7-9 GIBBONS ST REDFERN – MAJOR PROJECT 08_0112
 RESPONSE TO SUBMISSIONS ARISING FROM PUBLIC EXHIBITION OF ENVIRONMENTAL ASSESSMENT

DRAWING: WILLIAM LANE ELEVATION	JOB No. 5414
DRAWING No. SK-1303	ISSUE P3

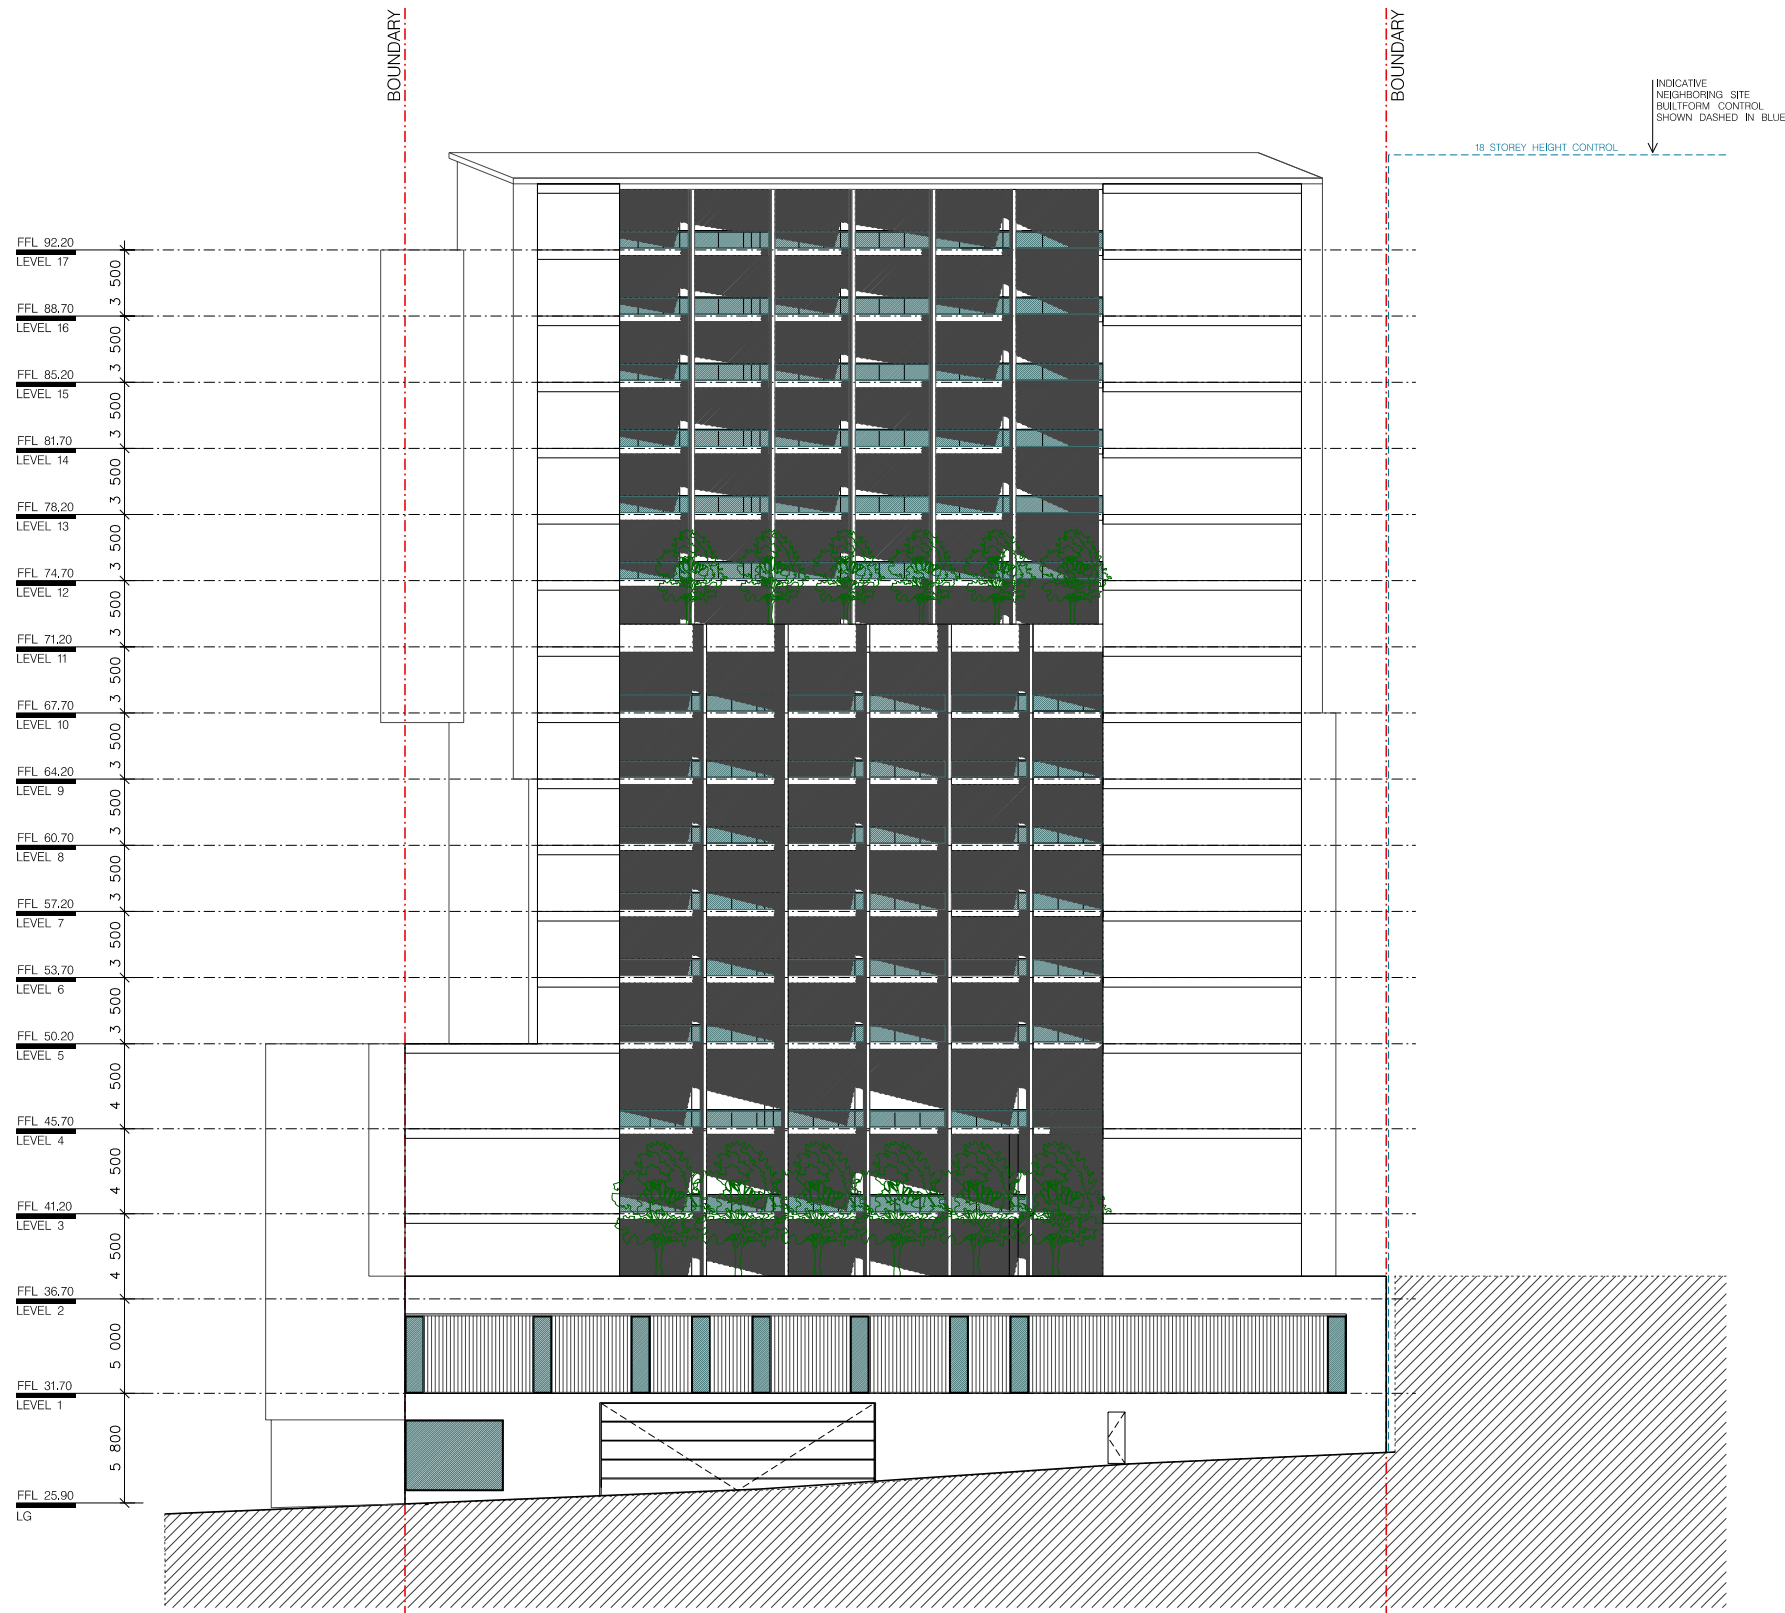
4.	<p>(Department of Planning)</p> <p>Amendments should be made to improve visual surveillance and activation along Marian Street from the podium retail and office floor space and on the lower levels of the eastern facade to provide surveillance over William Lane. This could include additional openings and articulation in the facade to increase interaction with the streetscape.</p>	<p>Plans have been revised to improve visual surveillance and activation over Marian St. However, it is considered impractical to activate the eastern facade of the development at ground level in William St as the ground level use of the development is a loading dock.</p>

56.	<p>(Redfern Waterloo Authority)</p> <p>William Lane Elevation</p> <p>While the RWA have previously identified William Lane as potential vehicle access for future development and not major pedestrian access, the proposed treatment of this elevation is considered inappropriate. The inactive frontage is exacerbated by the selection of materials which present a completely blank facade to the laneway at street level. This proposed William Lane facade when combined with the large vehicle access proposed on Marian Streets results in large area of inactive building facade at street level, which is inconsistent with BEP 1 and the draft Redfern Centre Urban Design Principles.</p>	<p>The detailed design of William Lane facade is being reviewed. However, the activation of William Lane at ground level is impractical as the ground level use within the development at ground level is a loading dock.</p>

01 SOUTH ELEVATION
1:200

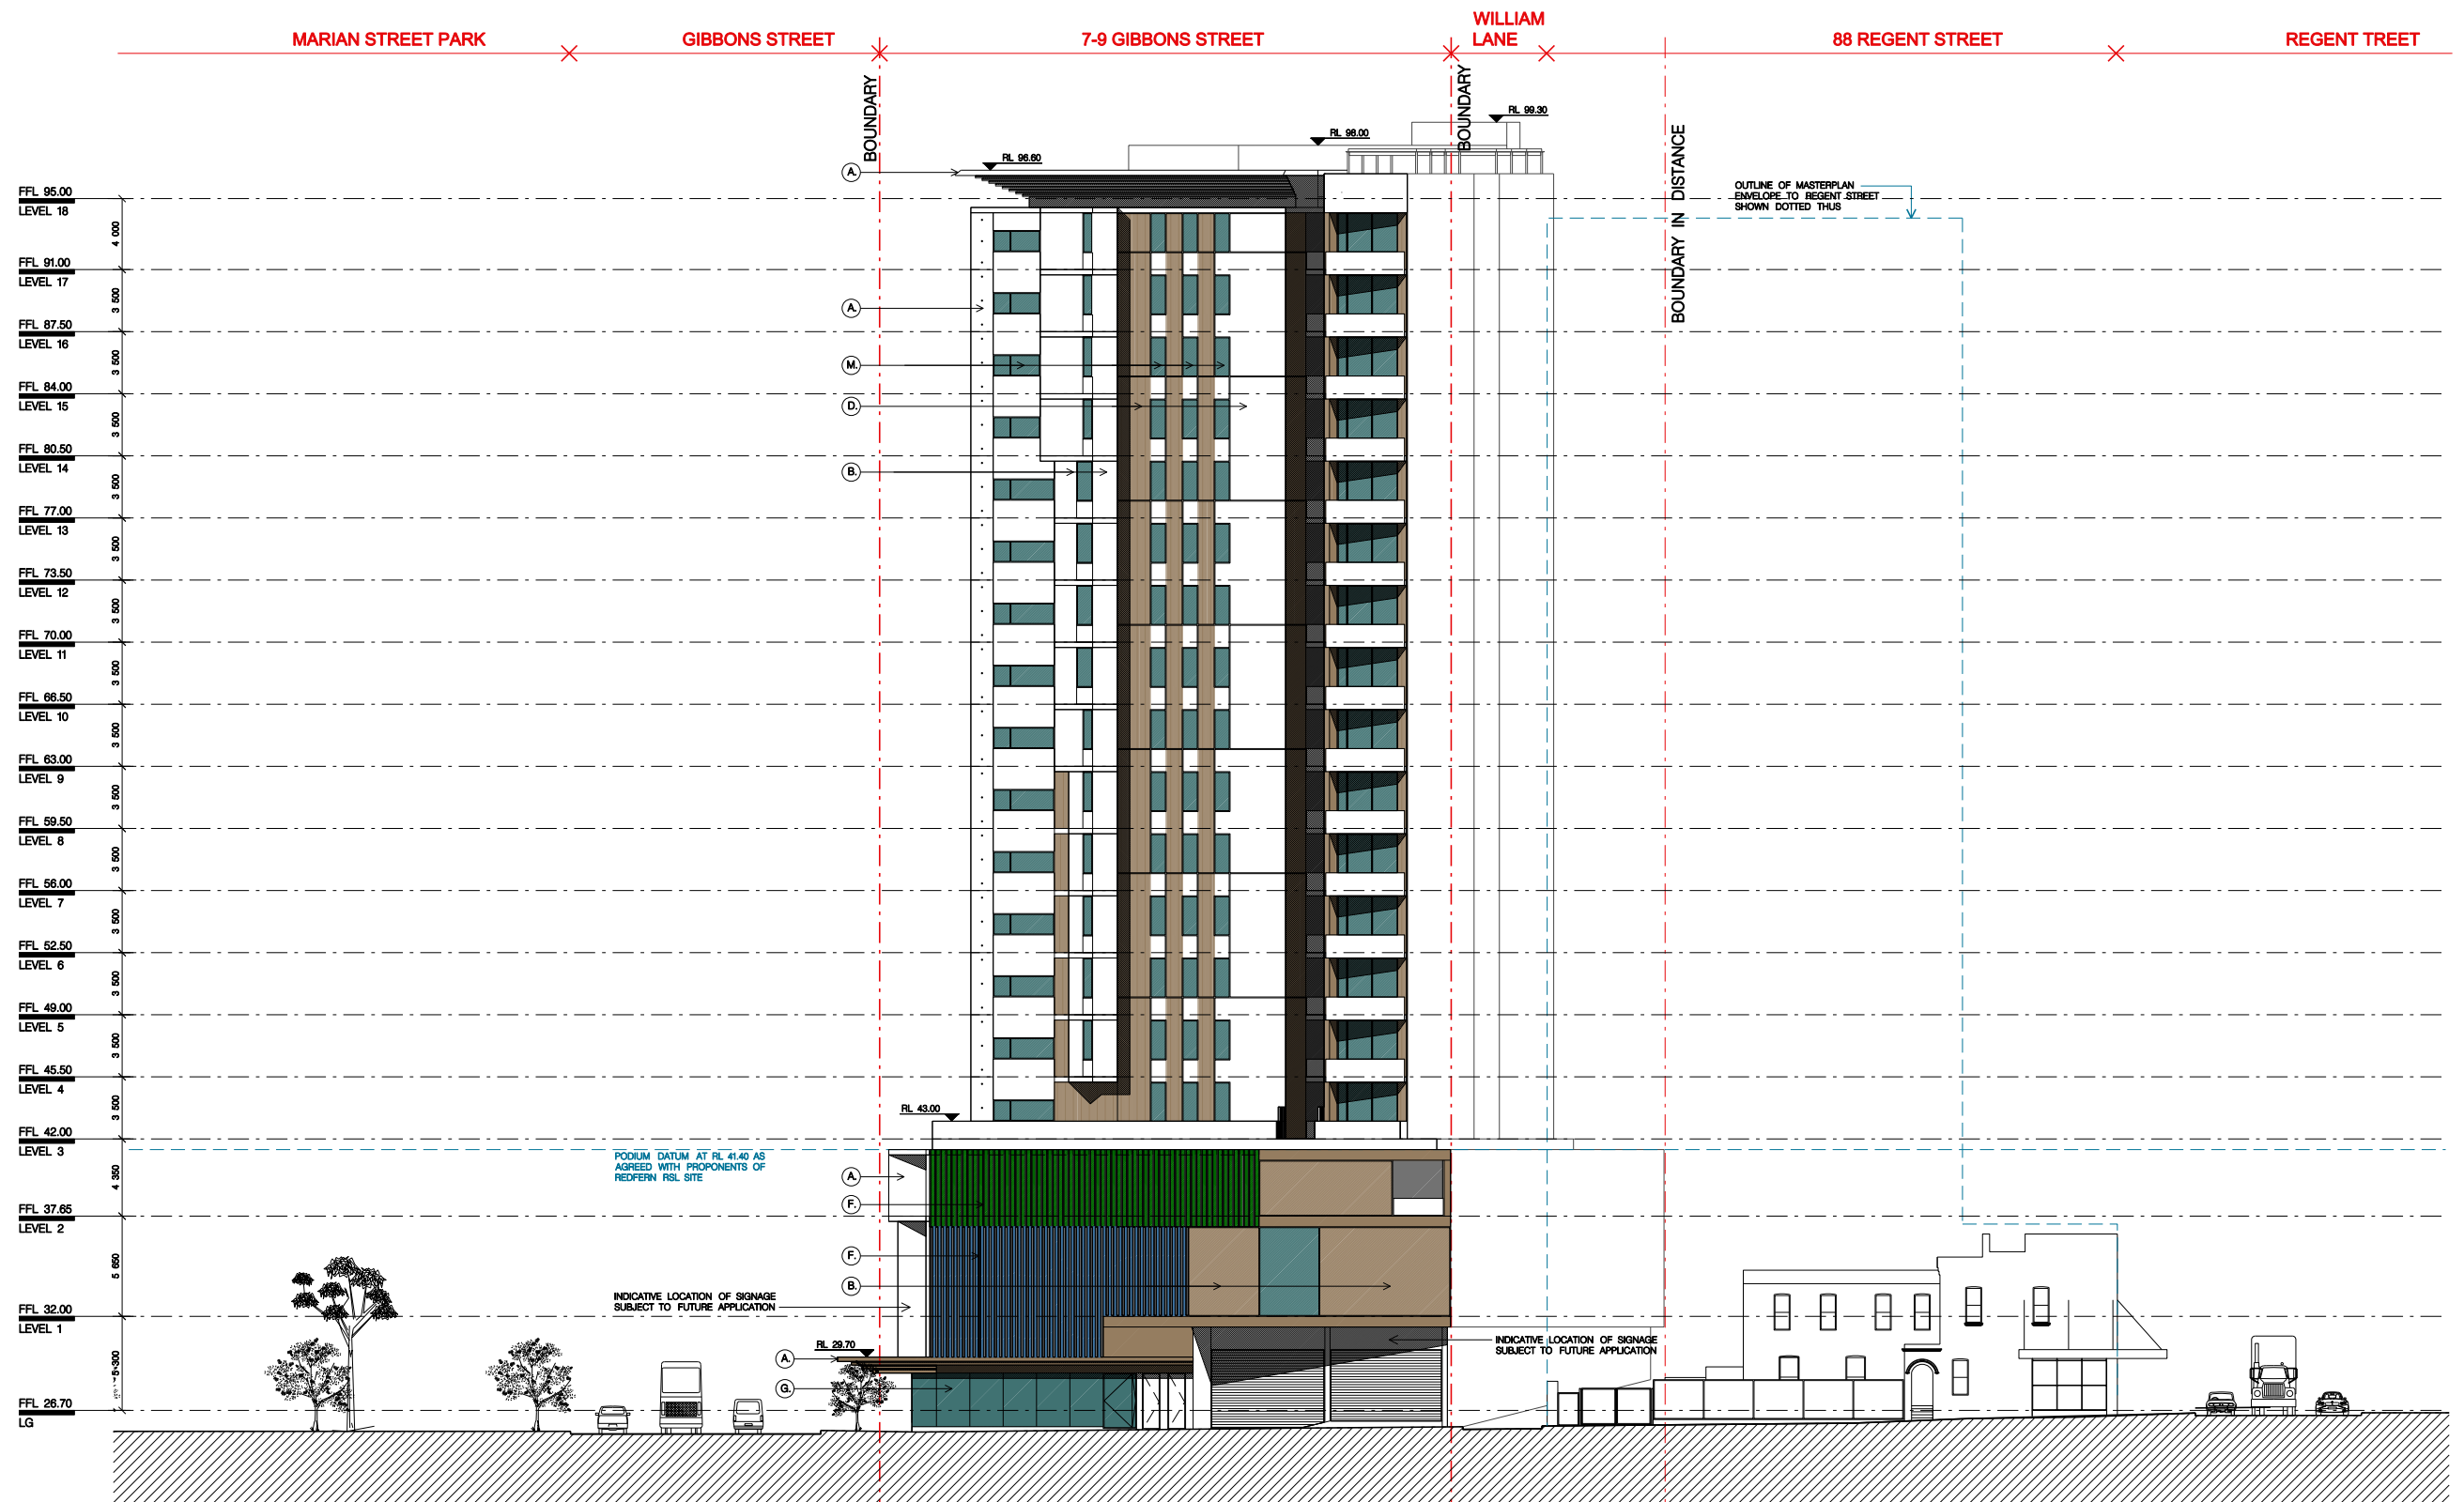
3.	<p>(Department of Planning)</p> <p>Consideration of further articulation of the southern facade of the podium including design elements to increase visual interest given its streetscape prominence. Consideration should be given to using a similar diversity of coloured and textured materials in the podium as has been designed on the western elevation of the podium.</p>	Plans have been revised

14.	<p>(City of Sydney) Design Issues</p> <p>The following design issues have been identified:</p> <ul style="list-style-type: none"> • The southern facade of the podium is a highly visible building element as viewed from Gibbons Street due to the low scale of the buildings to the south of the site which do not enjoy the increase in height that is attributed to the subject site under the Built Environment Plan and as

01 PROPOSED SHADOWS - 21 MARCH/SEPTEMBER 9AM
1:2000

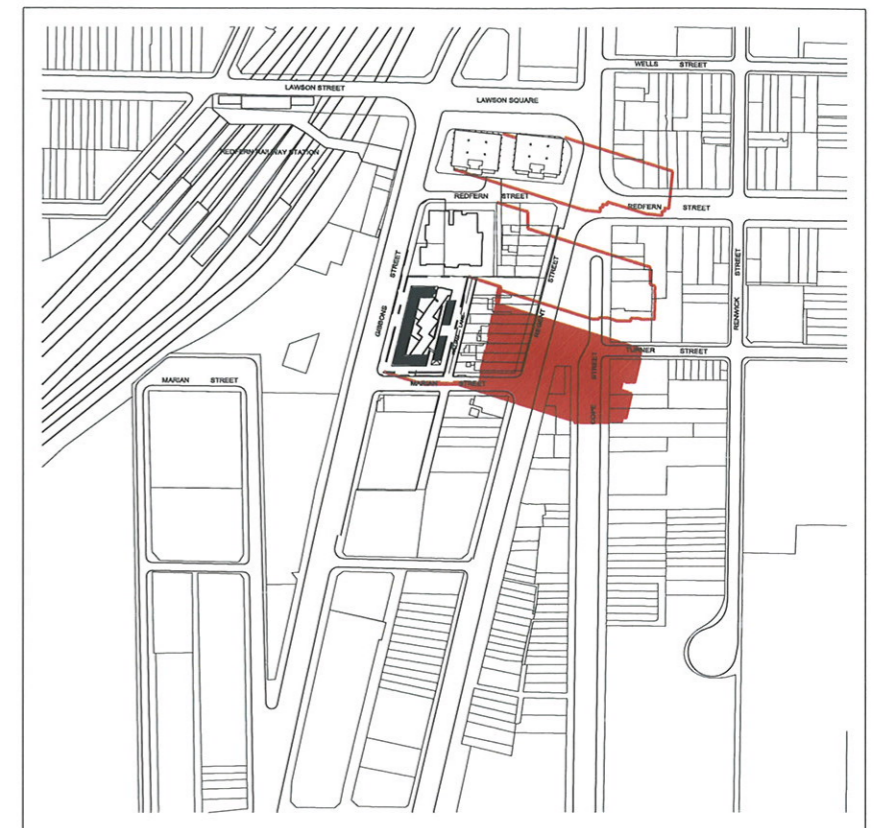
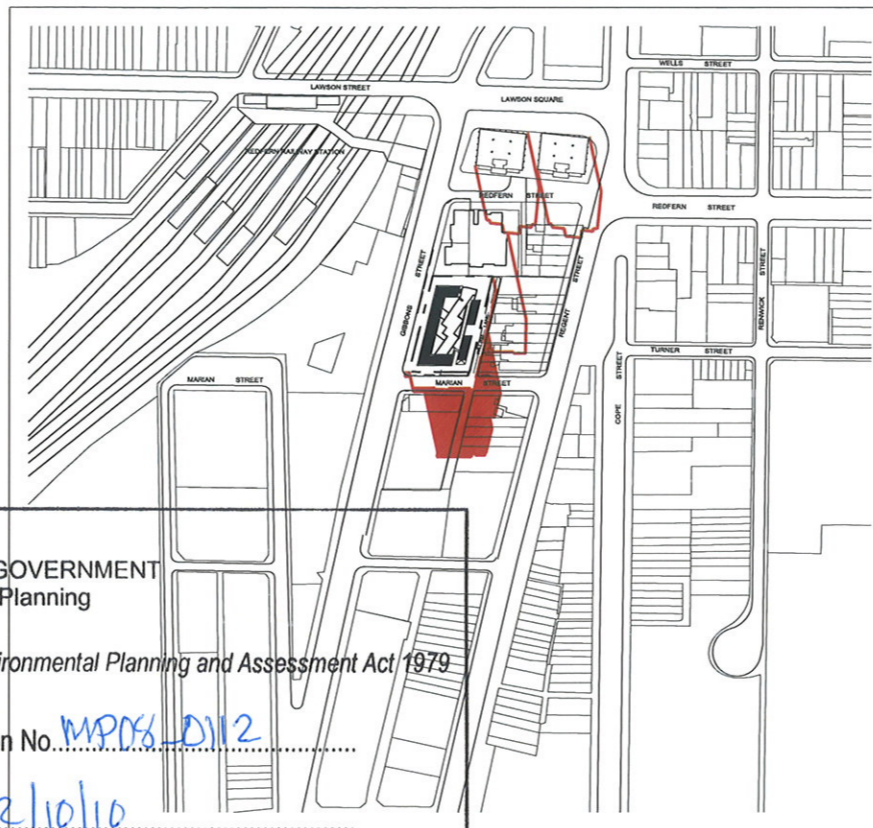
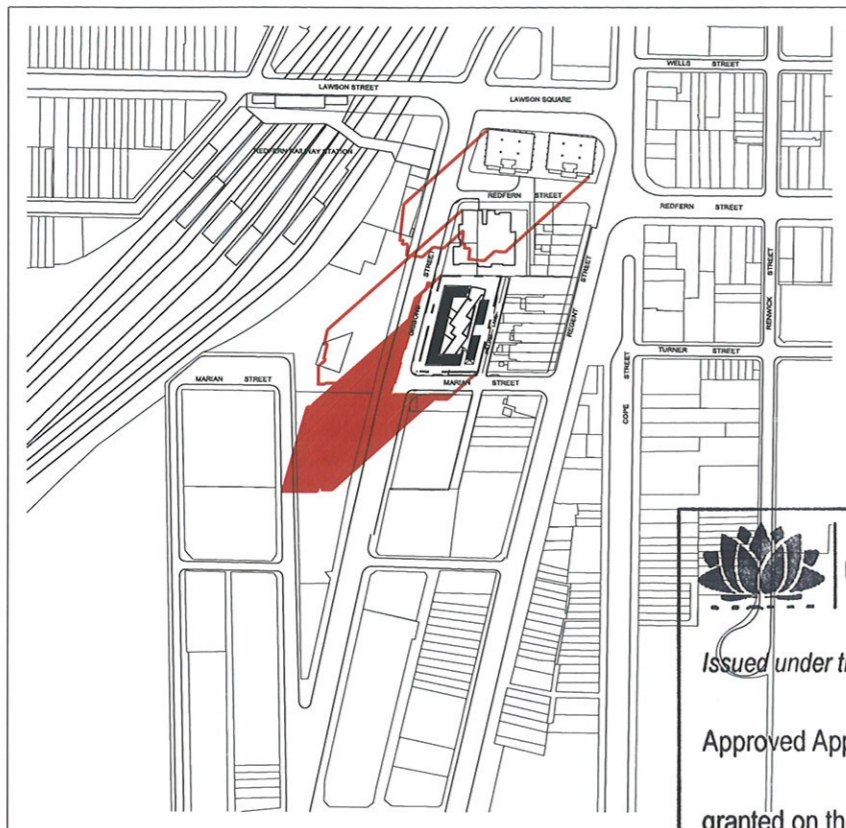
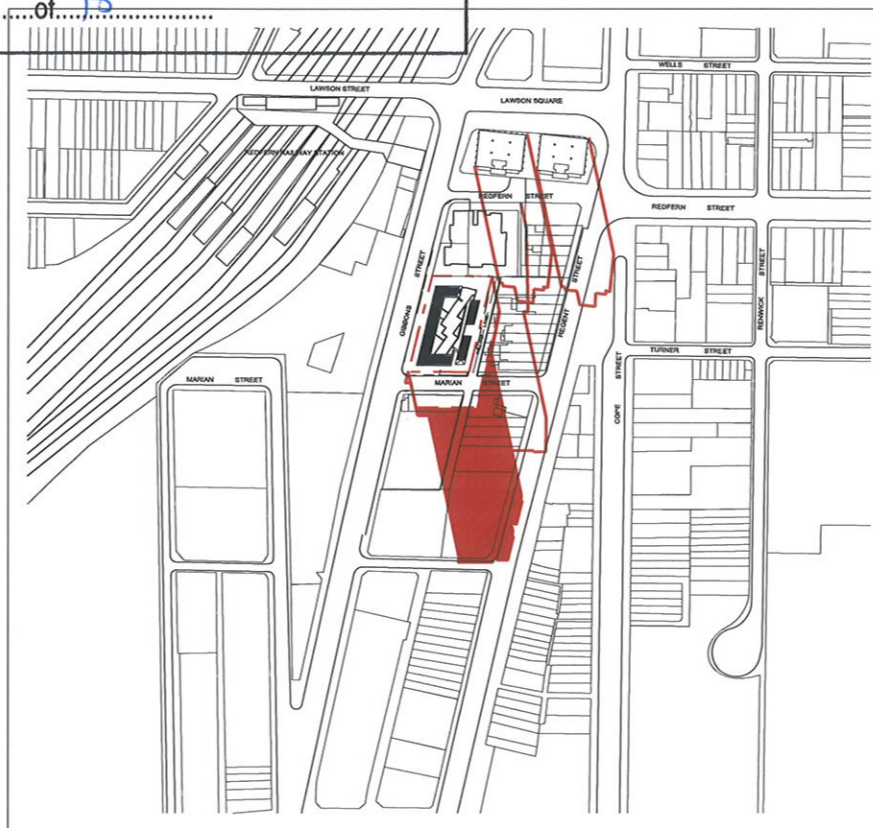
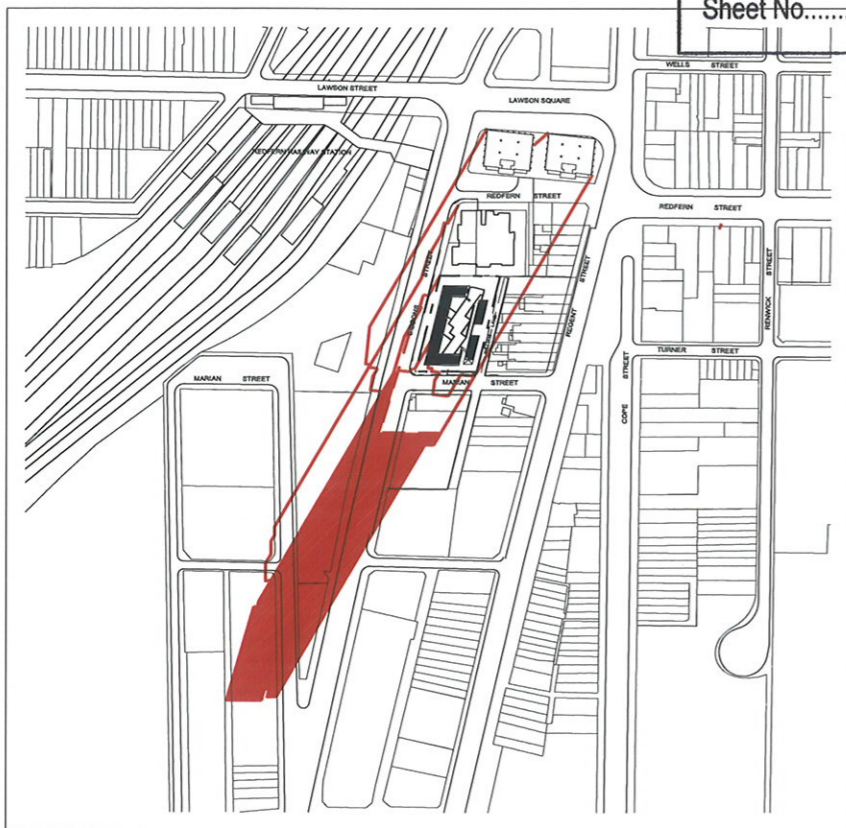
c) The proposal will cast shadows which will have detrimental impacts

Members of the public who live in Regent St, Turner St, Margaret St and Cope St have submitted that they will be detrimentally impacted by shadows arising from the proposed development.

Shadow Diagrams are attached in Attachment A and are reproduced above.

The extent of overshadowing is consistent with that generated by the building envelope controls established by the Redfern Waterloo Built Environment Plan by way of its FSR, height and podium setback controls.
